389 HARLINGTON ROAD, UB8 3JE
Revisions to outline planning application 55857/APP/2017/2608

The scheme that illustrates the development proposed by the above outline planning application has been reconsidered in the light of detailed comments you made on behalf of the local planning authority on the 12th October. Although made late in the day, we have found them very constructive and our client's team, led by Leo Panipucci the project architect, has revised the layout, form and appearance of the building to produce a better scheme and is now, we believe, worthy of the support of the local planning authority.

The development proposed has been changed from six two-bedroom flats on two floors to five two-bedroom flats over three floors. The 'Scheme Overview' overleaf expands on this. The description of development will need to be amended and the planning application put out to further consultation as we have discussed and agreed.

DATE: **22.10.17** DRAWN BY: **LP**
SCALE: **1:100@A2** REVISION: **A**
JOB NO: **17107** DWG NO. **22**

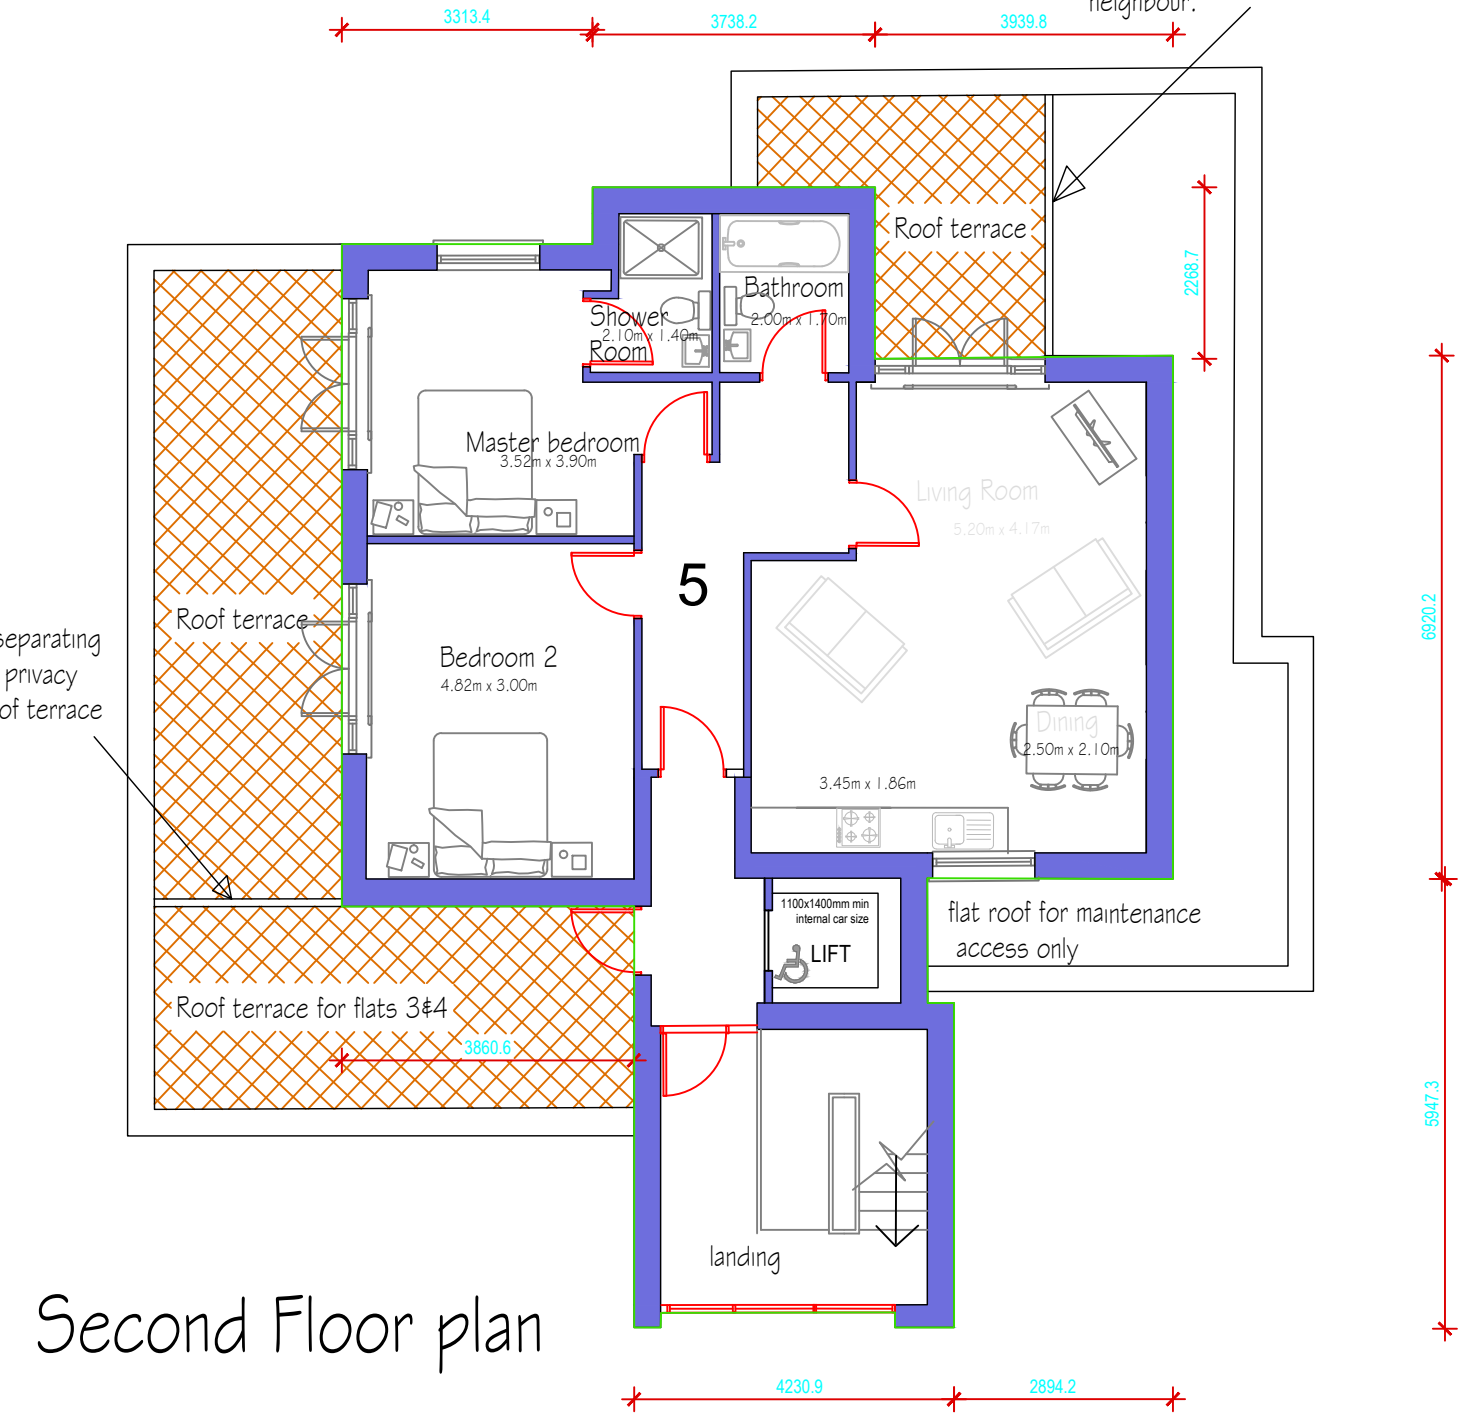
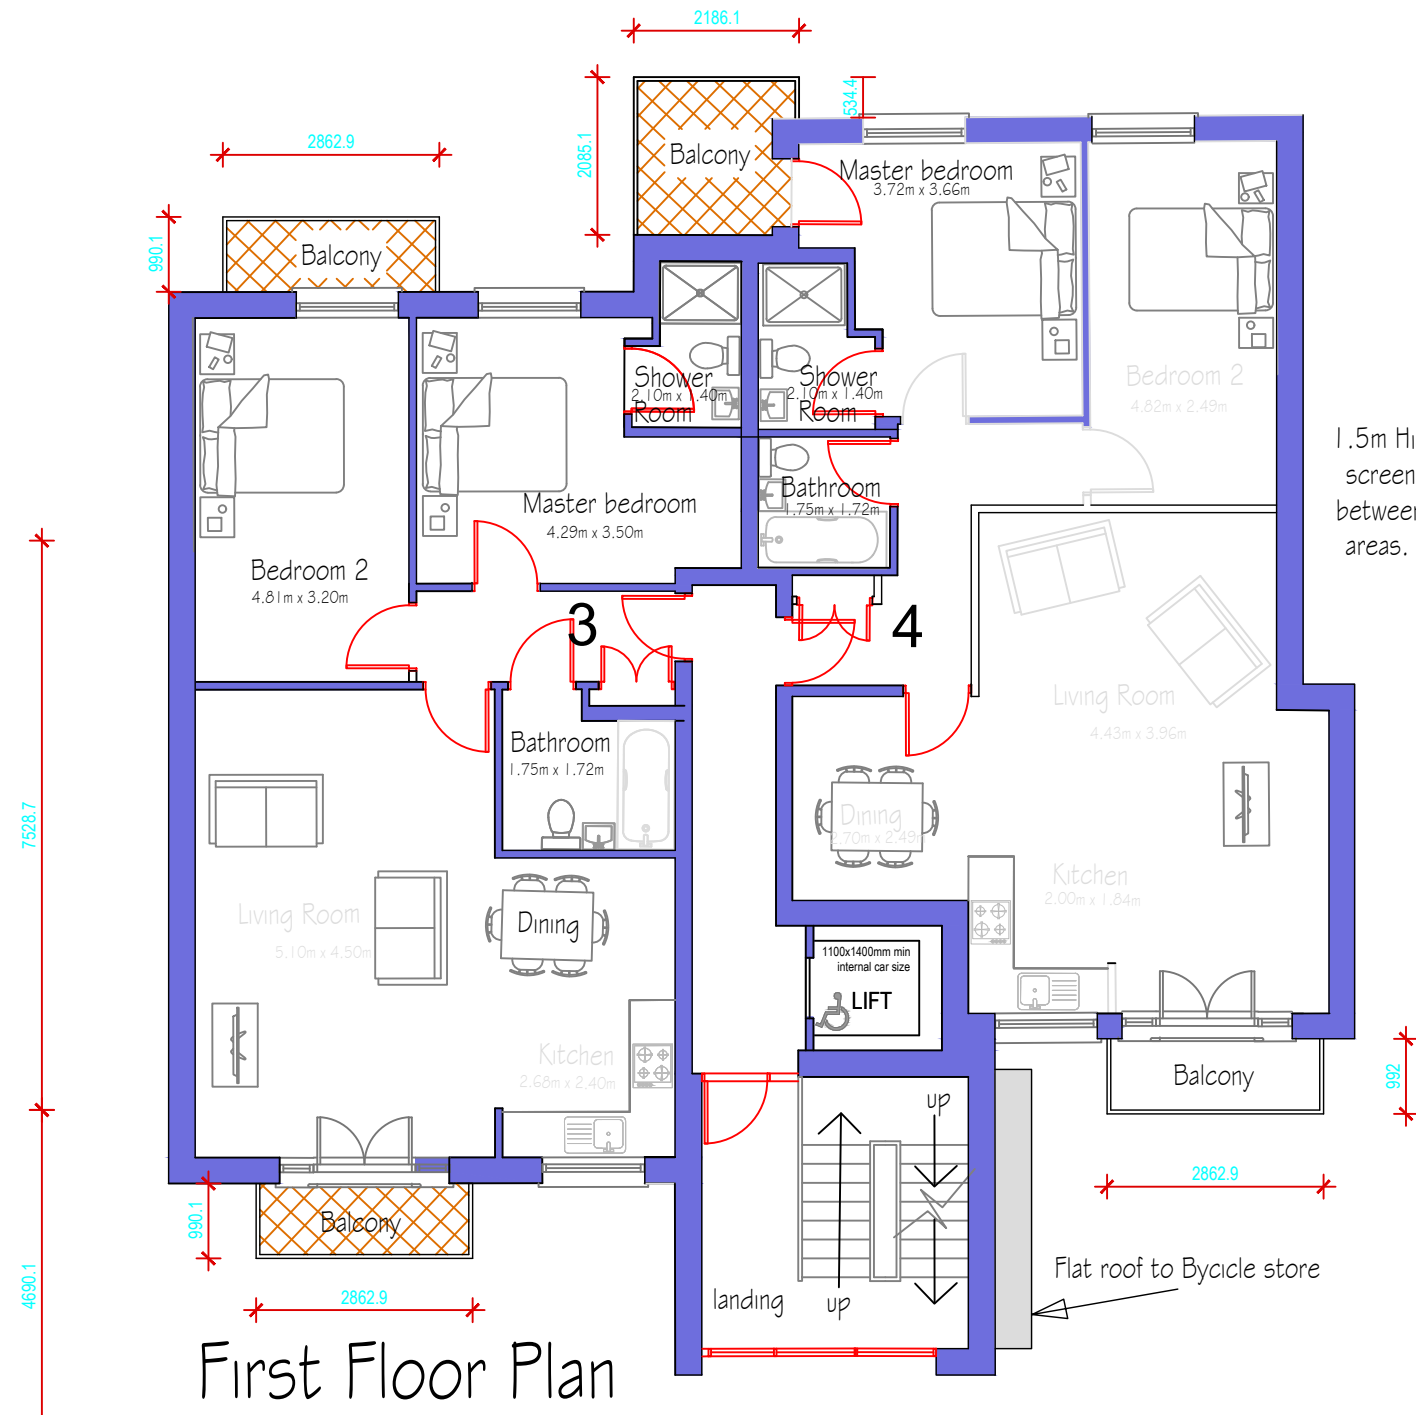
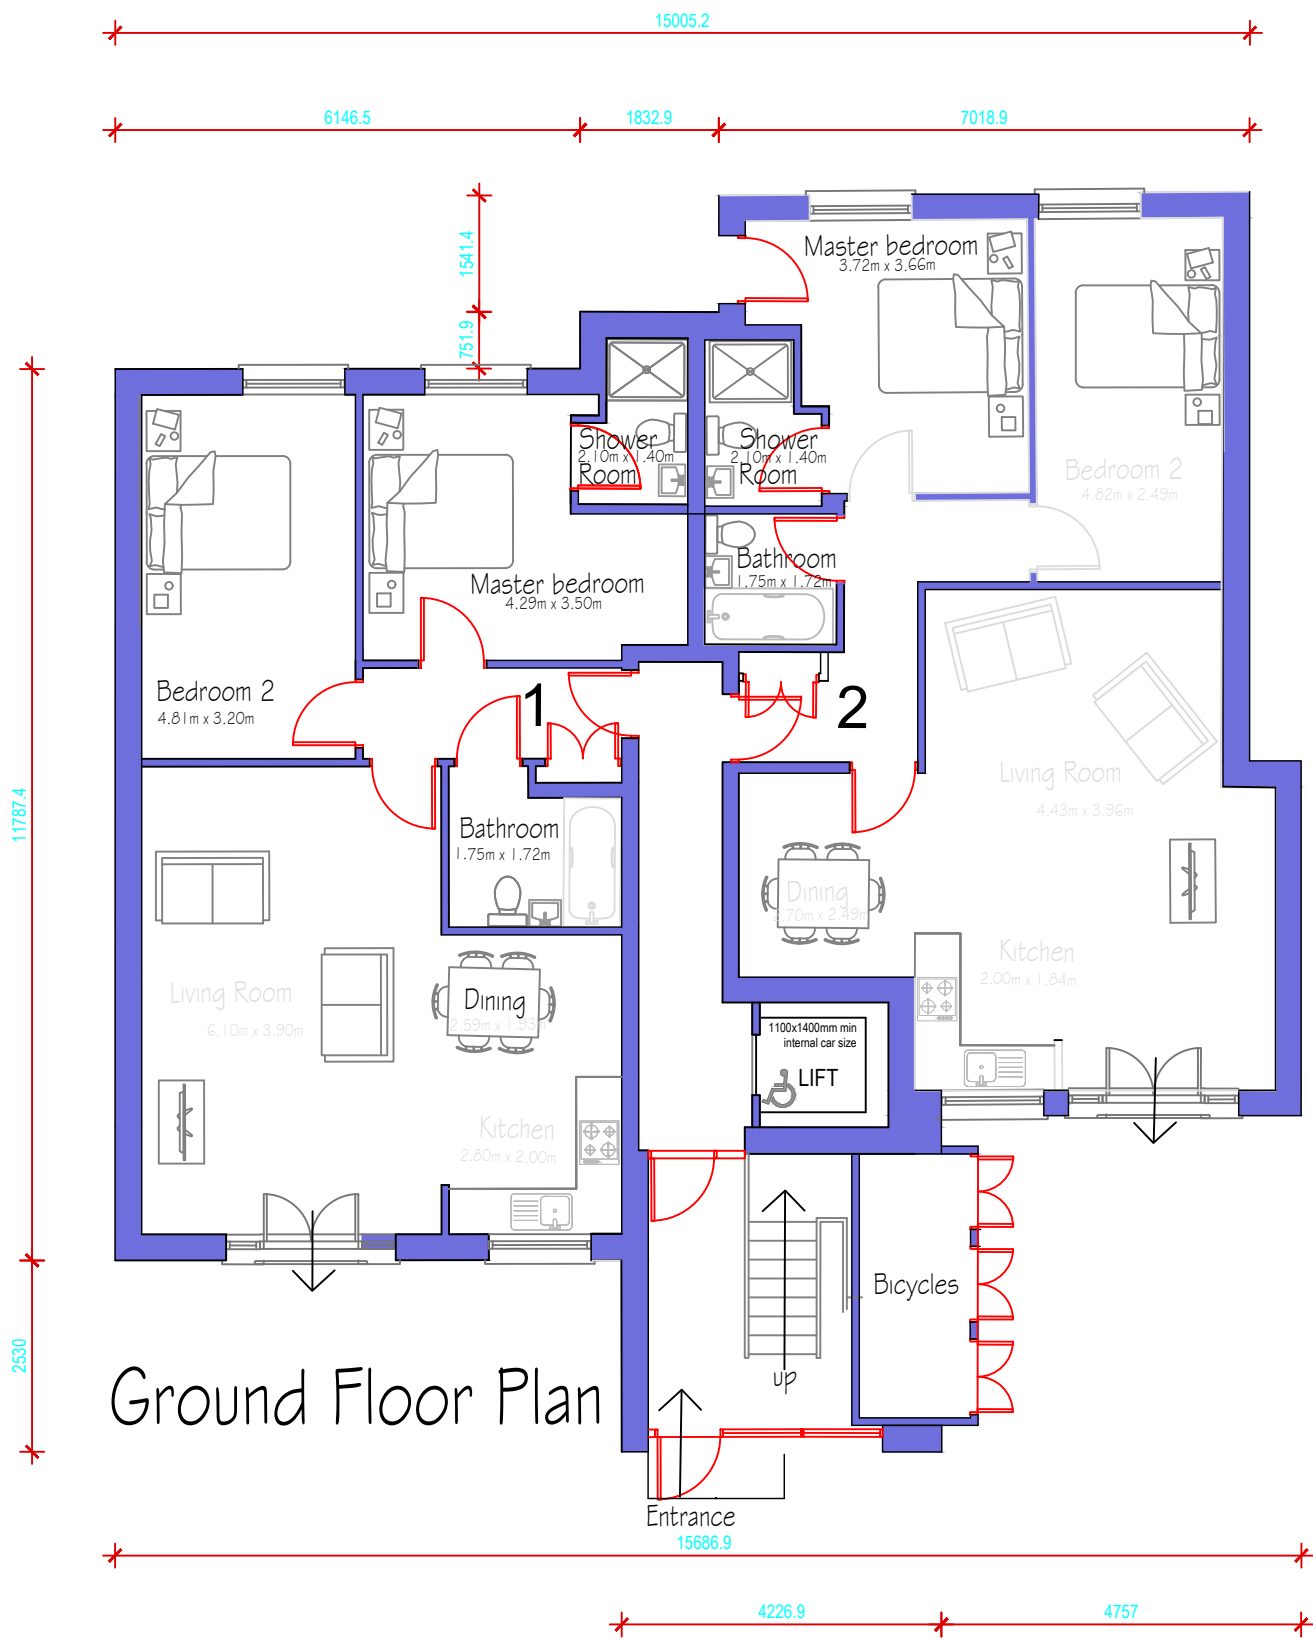
2. The development is too close to the boundaries to the side and rear. This would have an unacceptable overbearing impact on the house and garden next door.

3. There would be insufficient usable amenity space at ground floor level. It consists of a thin strip around the building rather than a usable area. There does not appear to be direct access to this space from more than one of the flats. Access would be through a very tight gap between the building and the fence.

4. Whilst a roof garden may provide additional amenity space, the access is not from the individual flats and the partitioning up of the area into 9 m2 plots would not lead to a lot of privacy.

8. There would be windows at ground floor level looking out onto fences at close quarters. This would give a poor outlook for the residents.

9. At first floor level there would be bedroom windows to the side that would directly overlook the gardens of the neighbouring houses and be located only 2 - 4 m from the boundary.

10. Some of the flats are slightly below the minimum internal floor area of 74 m2 required for a 2 bedroom, 4 person flat.

The reduced scale of the building means that it has been moved away from the boundary at each side to a minimum distance of 1.4 metres. This minimum separation is exceeded considerably for the majority of the boundary length.

The distances from the rear of the site boundary with No.387 Harlington Road are 4.97m from the window to Bedroom 2, 5.17m from Bedroom 1, then progressively 7.83m and finally 8.19m. This ensures that sufficient space is provided between the building and the garden of No.387 Harlington Road.

The reduced footprint ensures that a larger and wholly usable area of amenity space is provided to the rear of the block. The landscape architect that would contribute to the formulation of the reserved matters planning application scheme, Gordon Bell of Place Design+Planning, has endorsed the illustrative layout in this respect.

Individual balconies for Flats 3 and 4 provide amenity space direct from the flats at first floor level.

Additional amenity space for the first floor flats has also been incorporated at roof level directly opposite the lift. This is separated from the dedicated amenity space for Flat 5 by a 1.5m high screen.

All windows have been positioned to look into the front and rear of the development plot.

There are no windows facing onto the two side boundaries and in particular the existing bungalow at No.78 Corwell Lane.

Views from the third floor roof terrace to the bungalow at No.78 Corwell Lane have been restricted by a 1.5m high wall.

All five flats are materially larger than the minimum London Plan standard for two bedroom units which is 70 sq m.

Flat 1 = 74.2 sq m Flat 4 = 74.6sq m
Flat 2 = 74.6 sq m Flat 5 = 75.2sq m
Flat 3 = 74.2 sq m
